Your Ref: 000014171
Our Ref: AB/121/12/L
Please ask for:
Mrs A Gardner

7th December 2012

Application for listed building consent for 1 No new dwelling
Land adjacent to 84 Maltravers Street Arundel

Elevations & Section

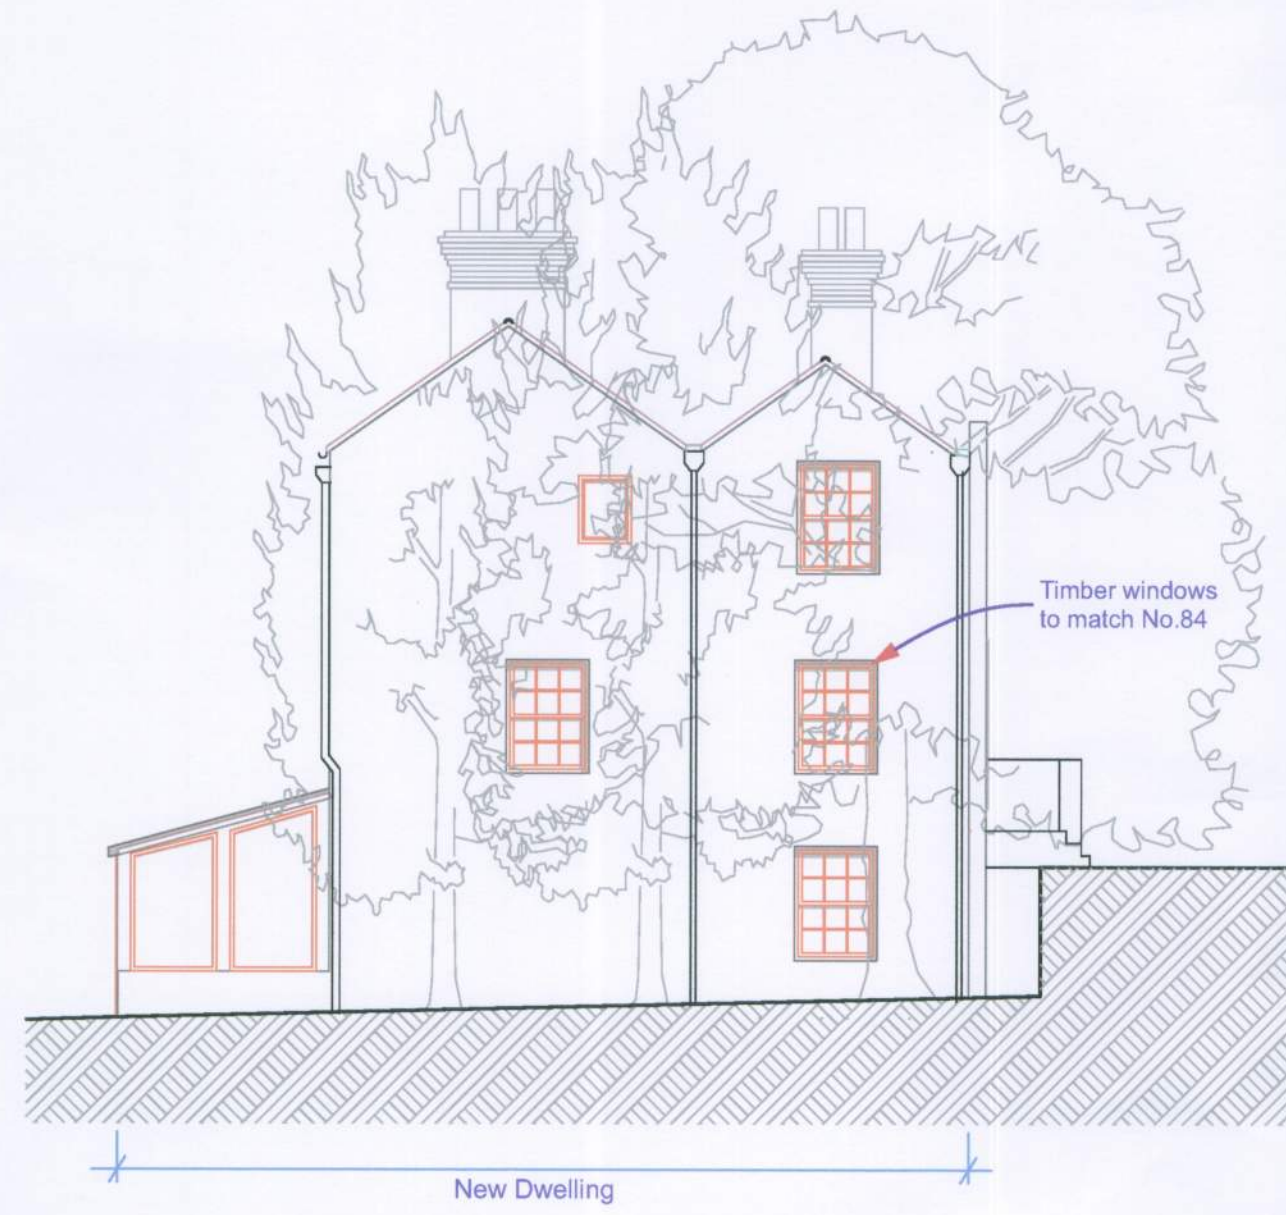
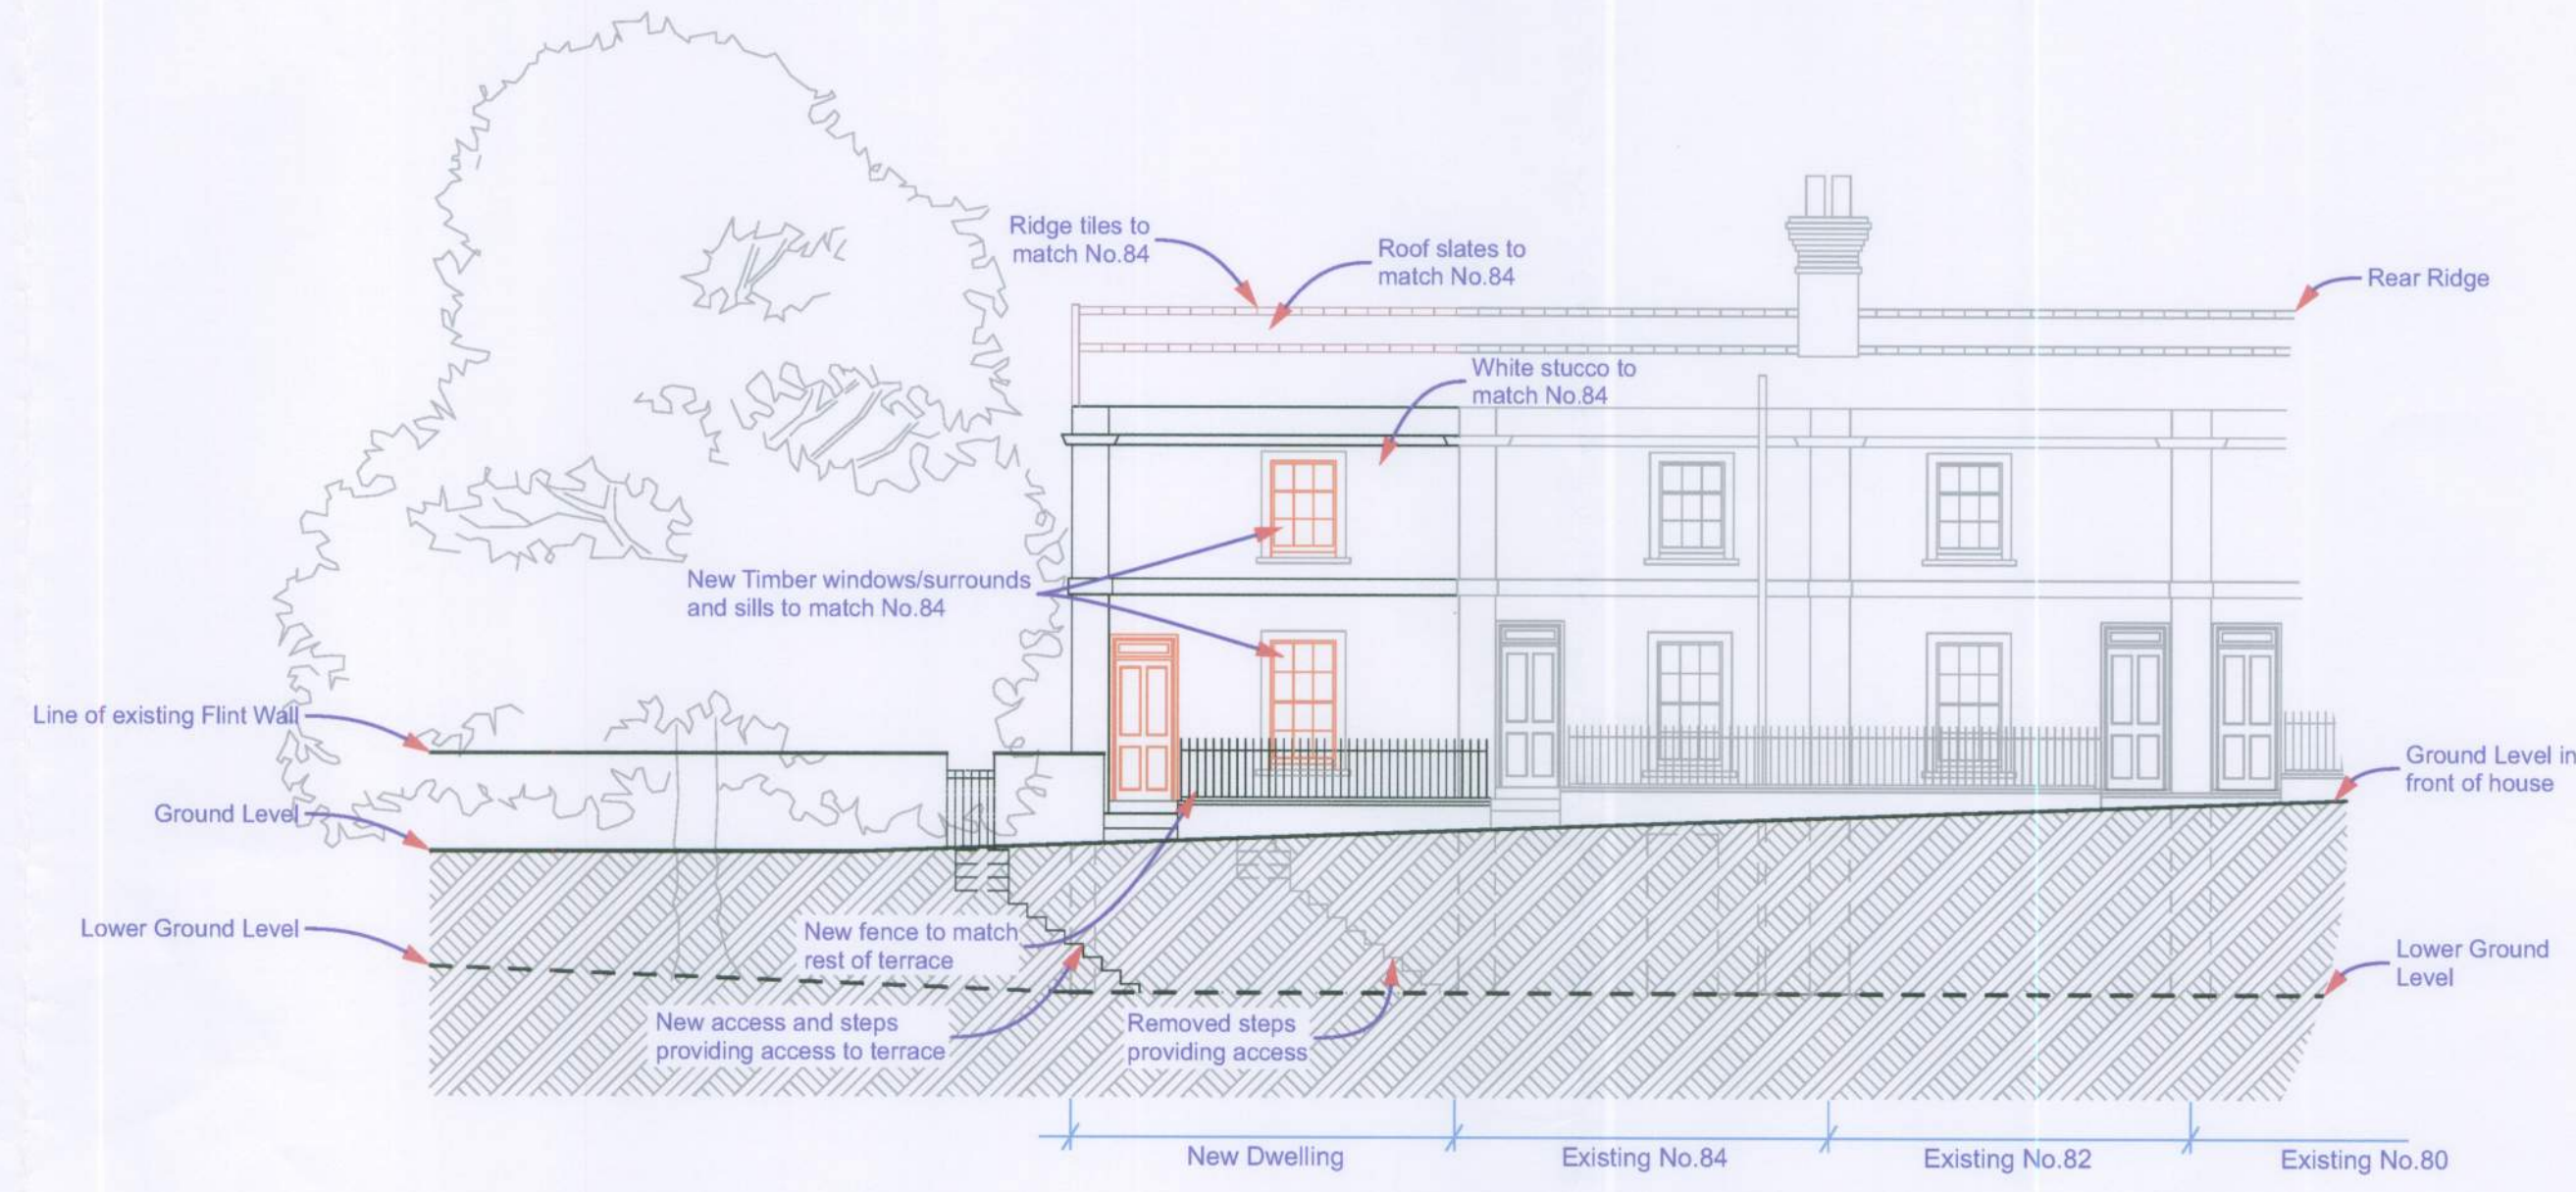
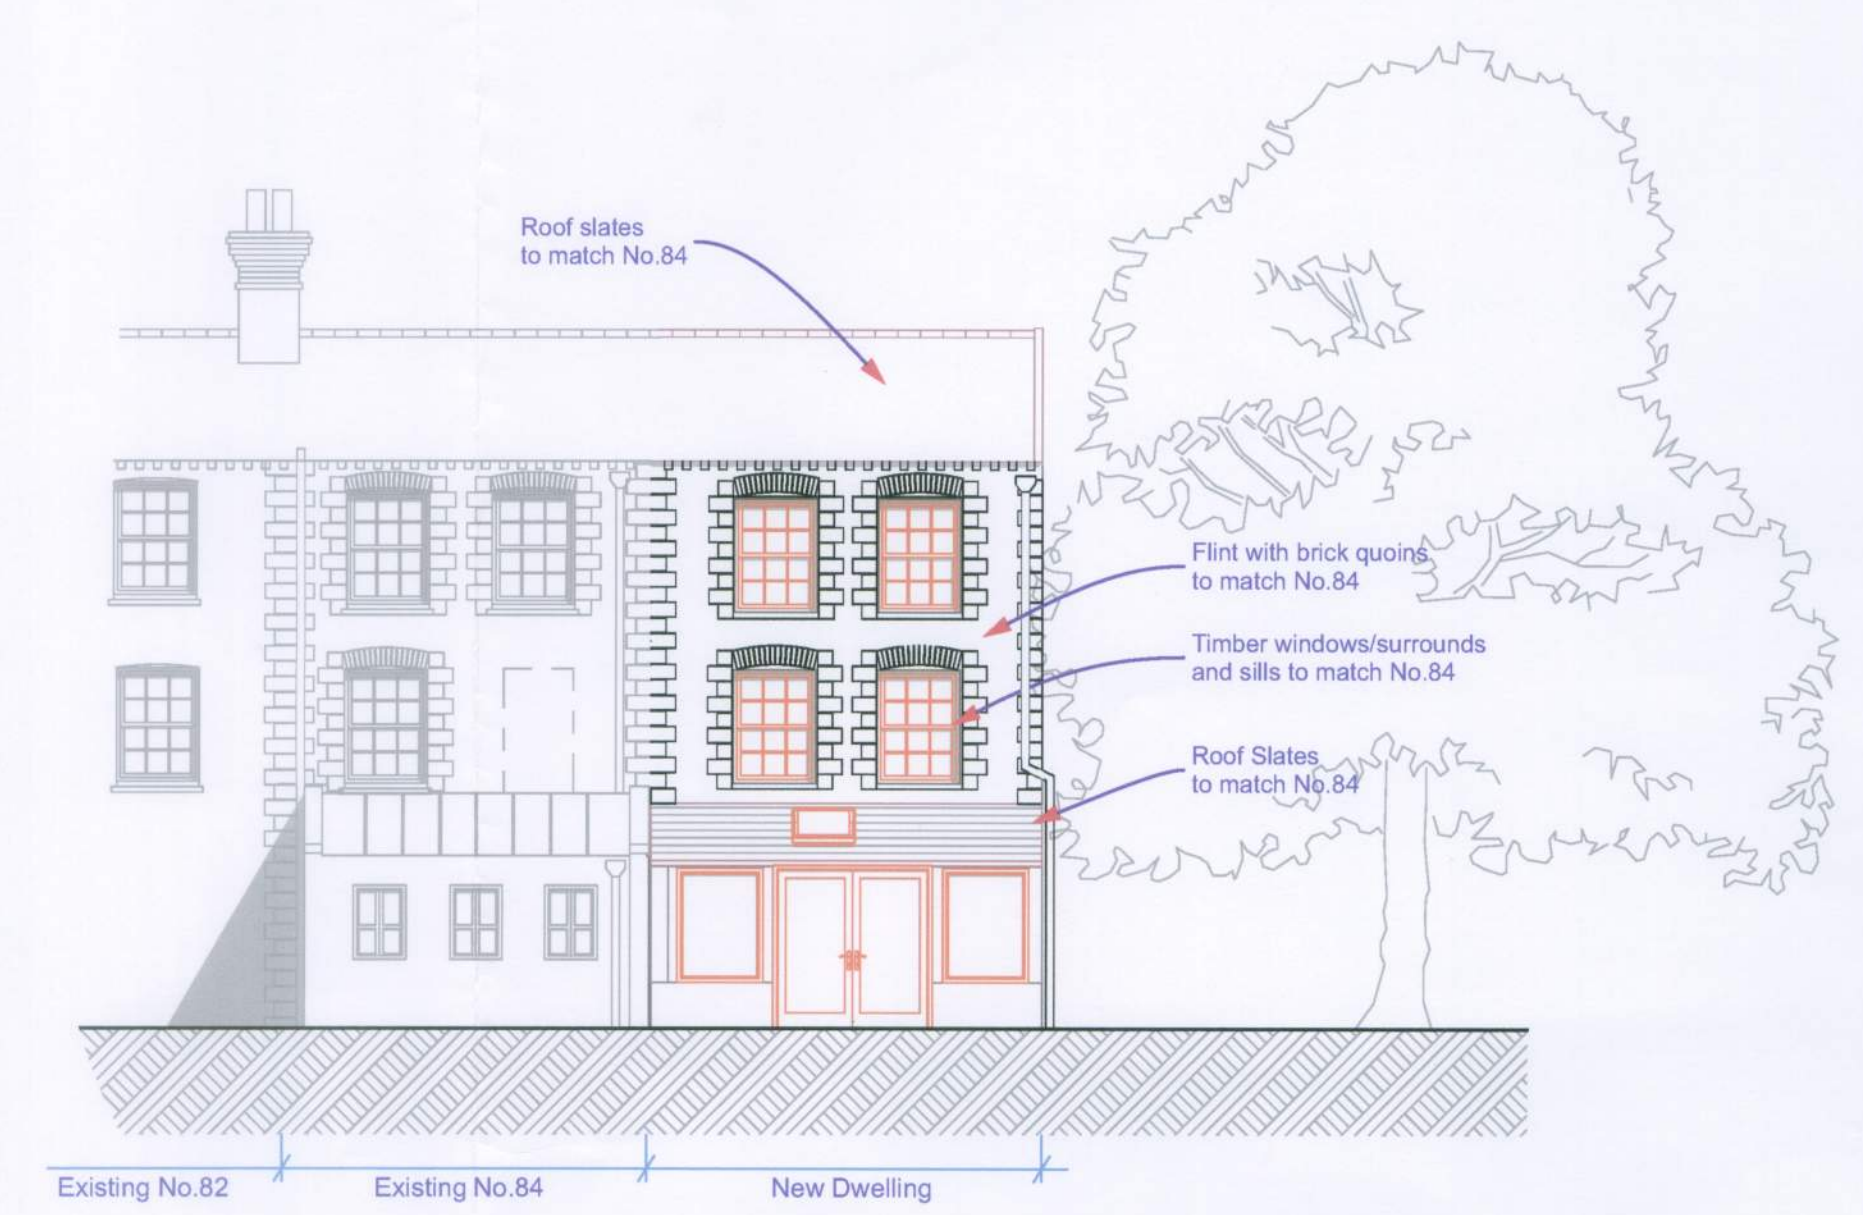
The Committee objected to the application on the grounds that the proposal still failed to sympathetically replicate the rhythm and important characteristics (height and location of the door; chimney and height of railings) of its neighbours and, as such, it would appear as an incongruous addition to what is otherwise a uniform and regular terrace of listed properties. It would therefore detract both from the character and appearance of the row of properties and its prominent and important setting at one of the main entrances into the Town of Arundel.
